I attach a copy of the District Council's letter which responds to the Examining Authority's requests for information at the Issue Specific Hearing 6 and its Rule 17 request for information.

Our ref : Vanguard deadline 8
Your ref : EN010079
Date : 30 May 2019

Application by Norfolk Vanguard Limited for an Order Granting Development Consent for the Norfolk Vanguard Offshore Wind Farm – Deadline 8 submission.

CAWSTON HIGH STREET - INTERVENTION SCHEME
Scale 1:500

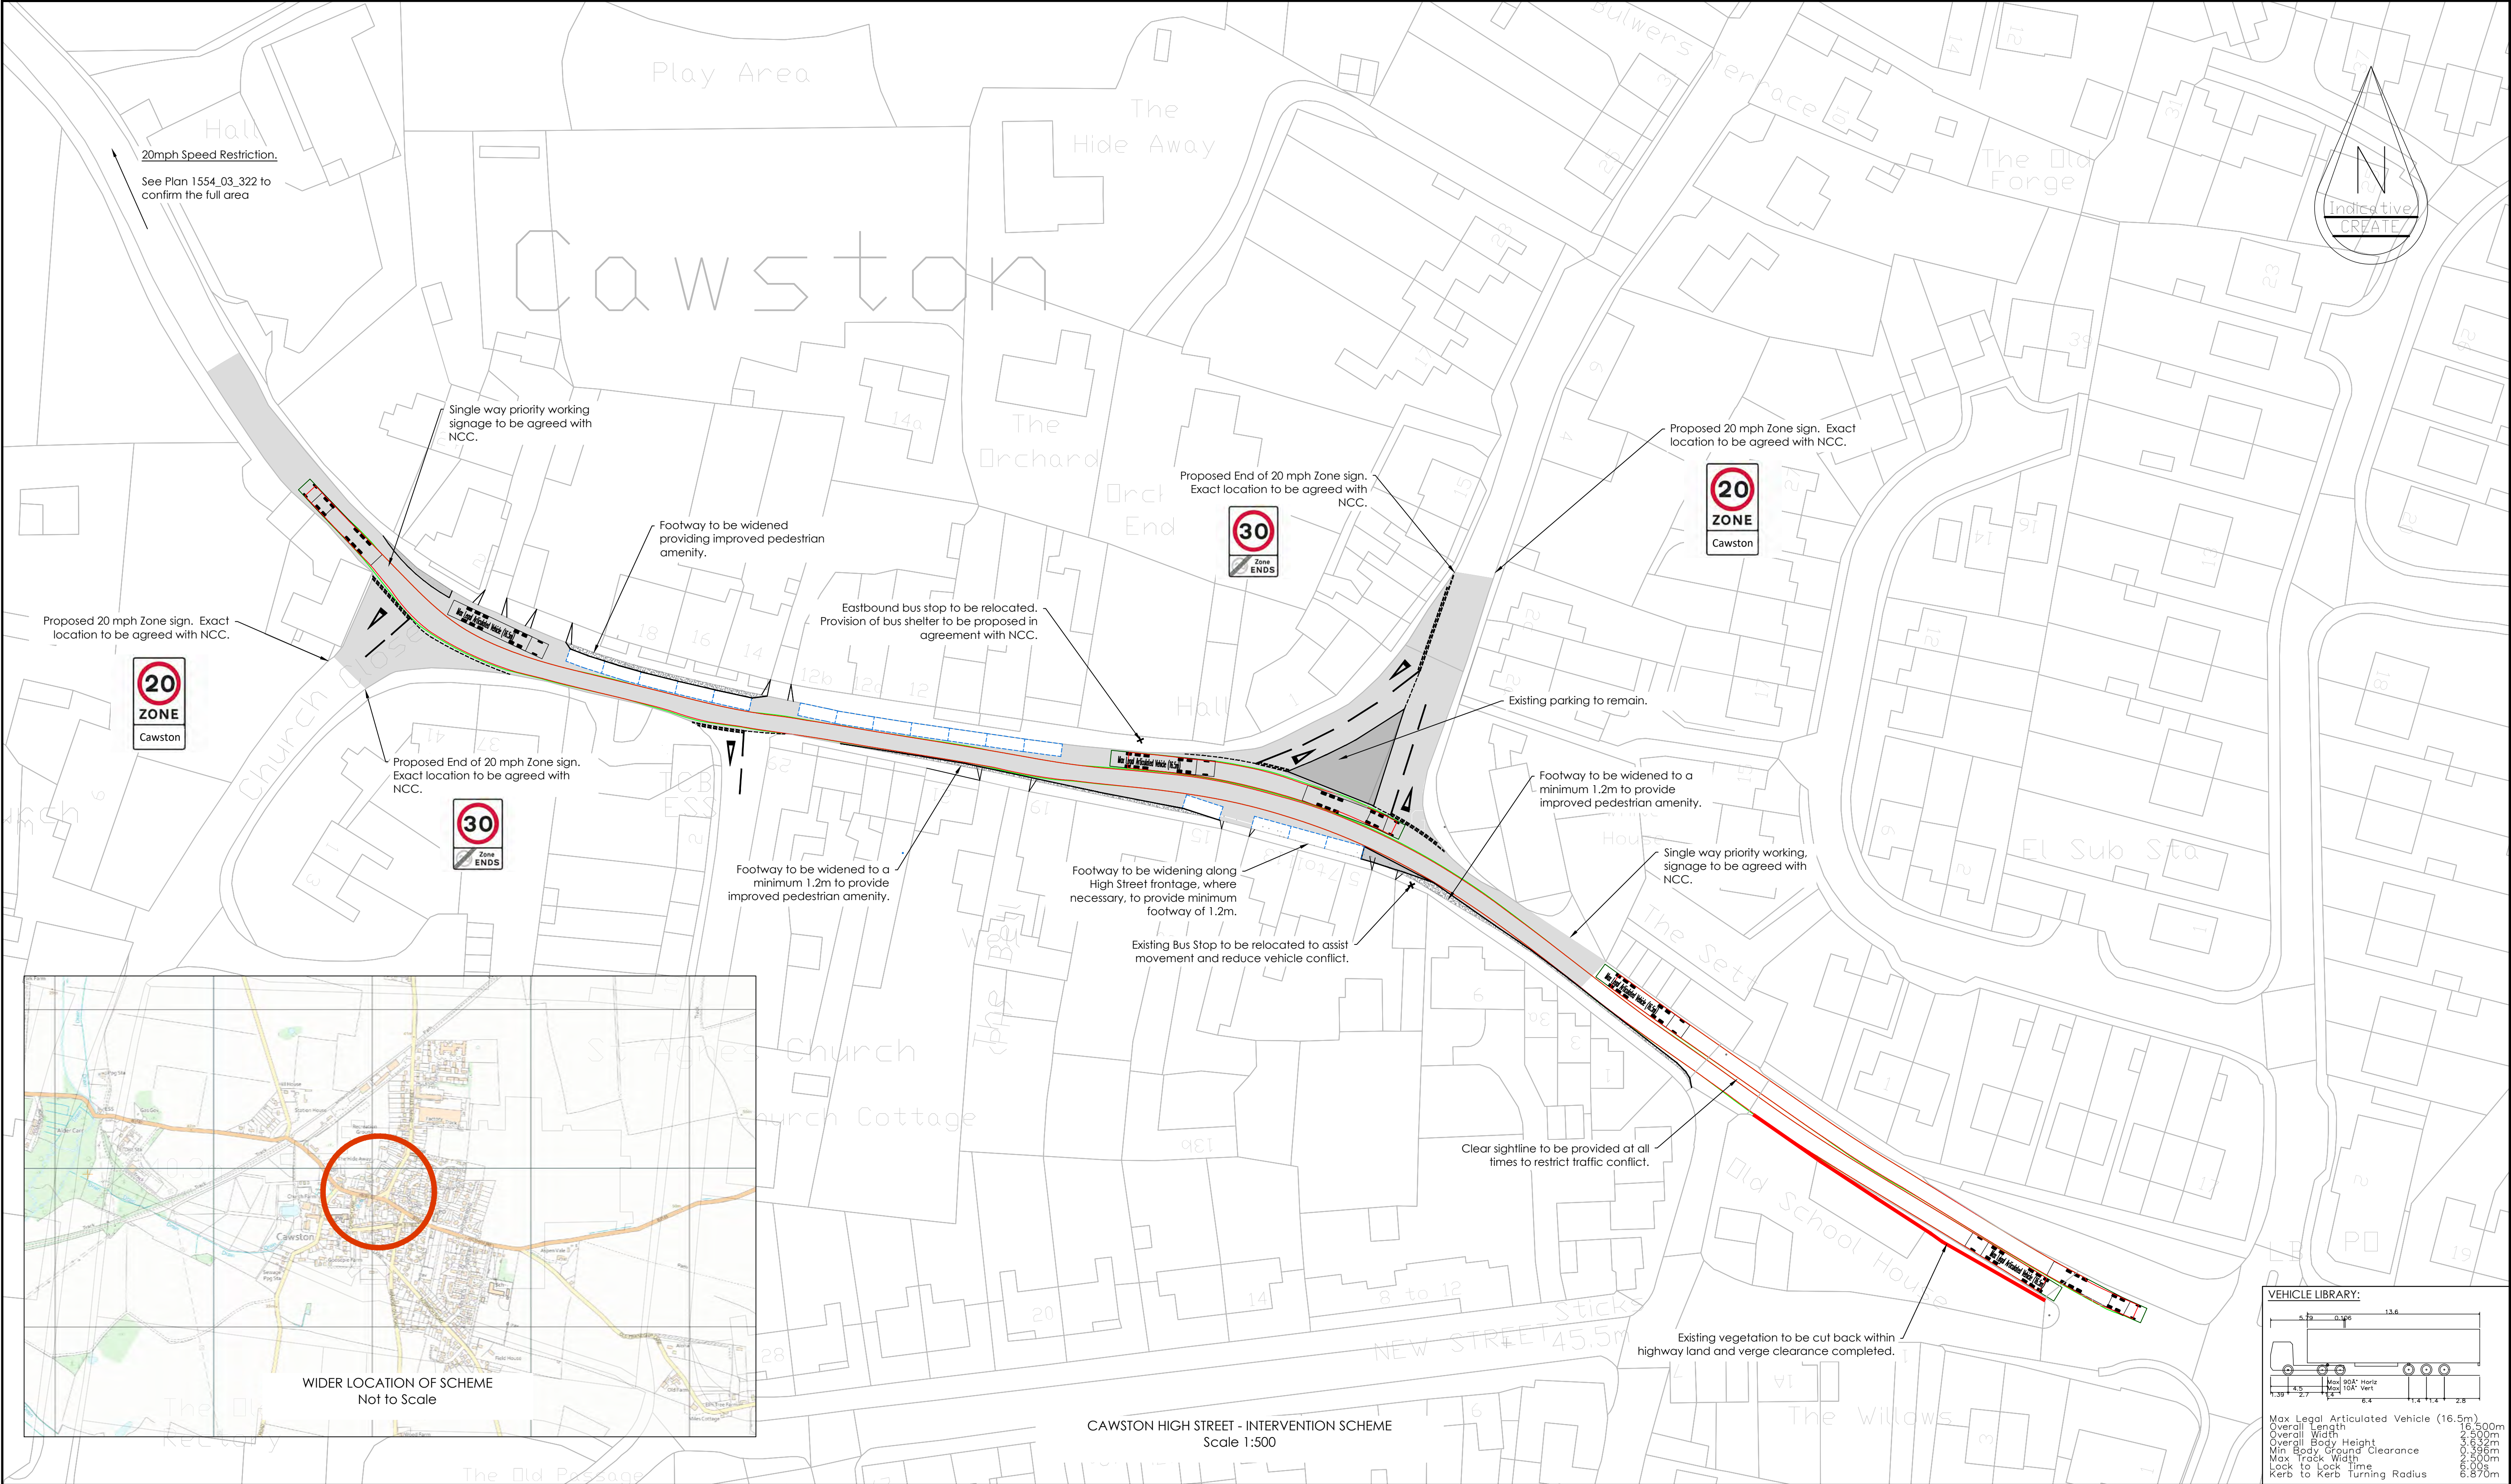
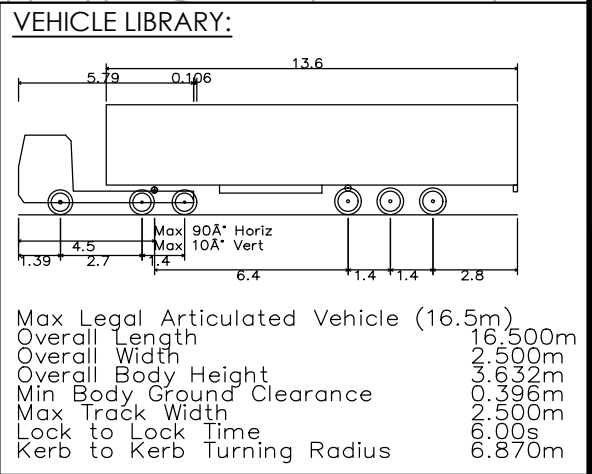
However the District Council's principal concern with the proposed mitigation scheme is that the proposed widening of that part of the footway outside 6 High Street, Cawston has the unfortunate effect of narrowing the carriageway and increasing the risk of the corner of the Grade II listed

Whitehouse Farm opposite being hit by a passing vehicle. This situation needs to be further assessed and addressed.
